## **BCA ASSESSMENT REPORT**

**OAKDALE SOUTH ESTATE, HORSLEY PARK  
BUILDING 1D**

**PREPARED FOR:  
GOODMAN PROPERTY SERVICES (AUST) PTY LTD**

Revision 2

Figure 5-4: Fire Brigade Access and Site Facilities for Lot 1D

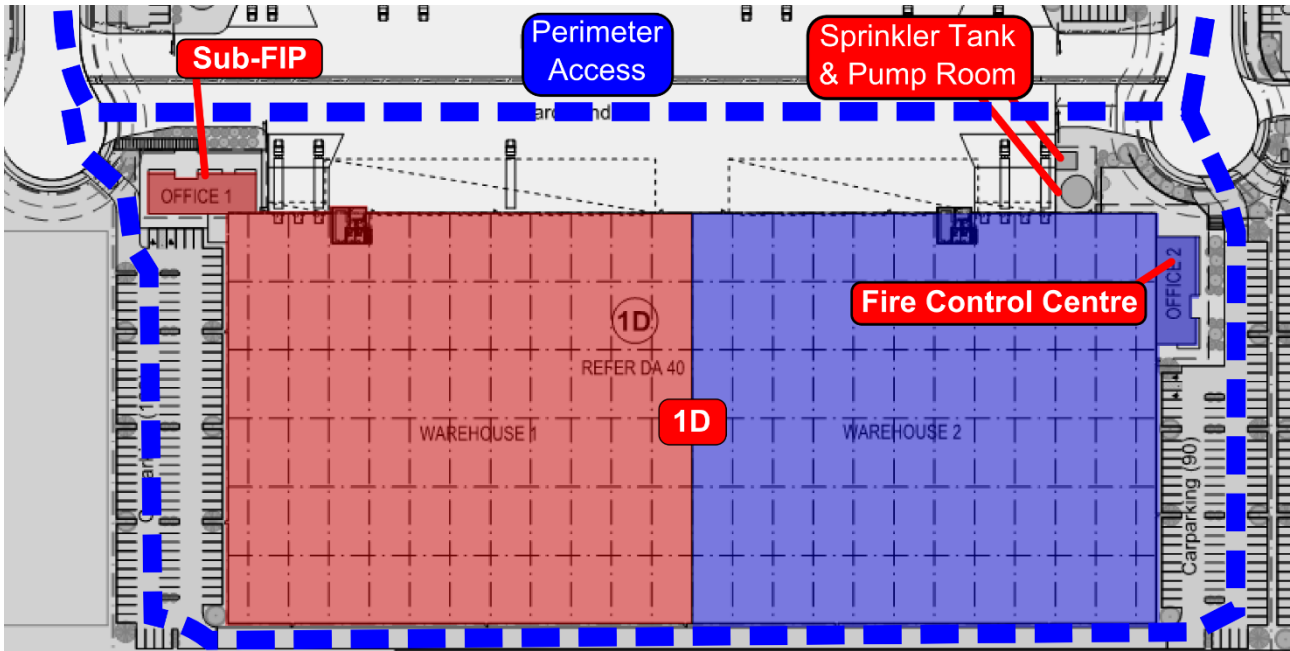
Comments: The proposed warehouse building does not comply with the provisions of C2.4 insofar as the vehicular access path is greater than 18m from the external wall of the building in the areas circled in red on the below mark-up. This non-compliance is required to be addressed as an alternative solution prepared

by the Fire Safety Engineer to demonstrate compliance with Performance Requirement CP9. Note: Any proposed Performance Solution will need to take into consideration that additional hazard that may result from the inclusion of Dangerous Goods Storage in the subject building.

Figure 8-4: DTS Non-Compliant Travel distances on Lot 1D

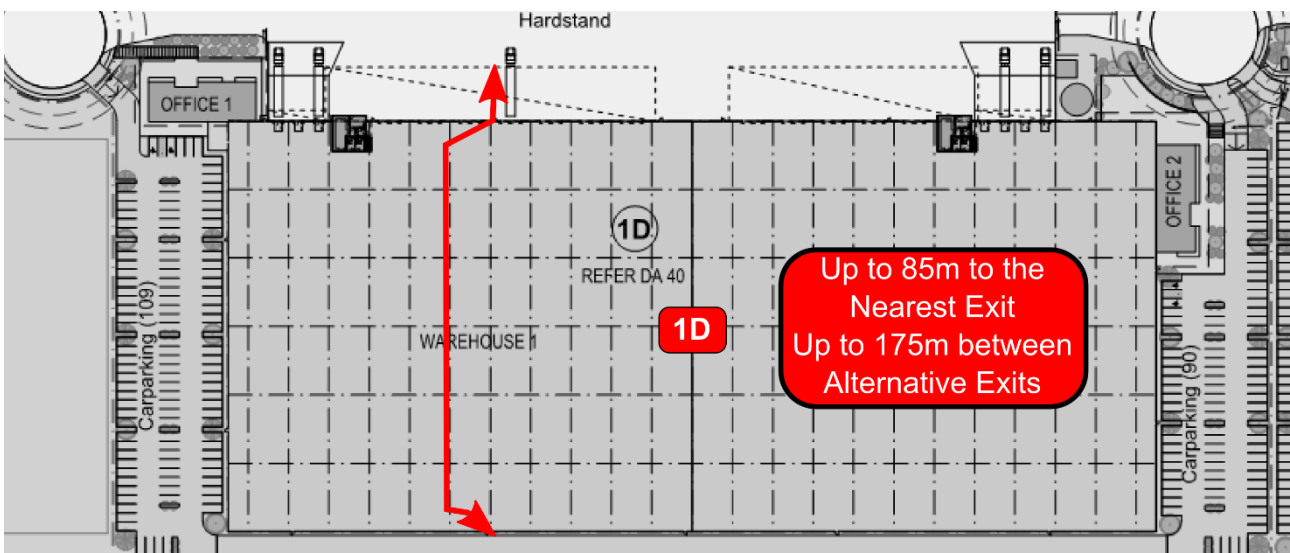
*Comments: The exit travel distances in the building are considered to be non-compliant with the requirements of Clause D1.4 in the warehouse areas where egress to the nearest exit is up to 80m.*

*The above non-compliance is required to be addressed as an alternative solution prepared by the Fire Safety Engineer to demonstrate compliance with Performance Requirements DP4 & EP2.2. Note: Any proposed Performance Solution will need to take into consideration that additional hazard that may result from the inclusion of Dangerous Goods Storage in the subject building.*
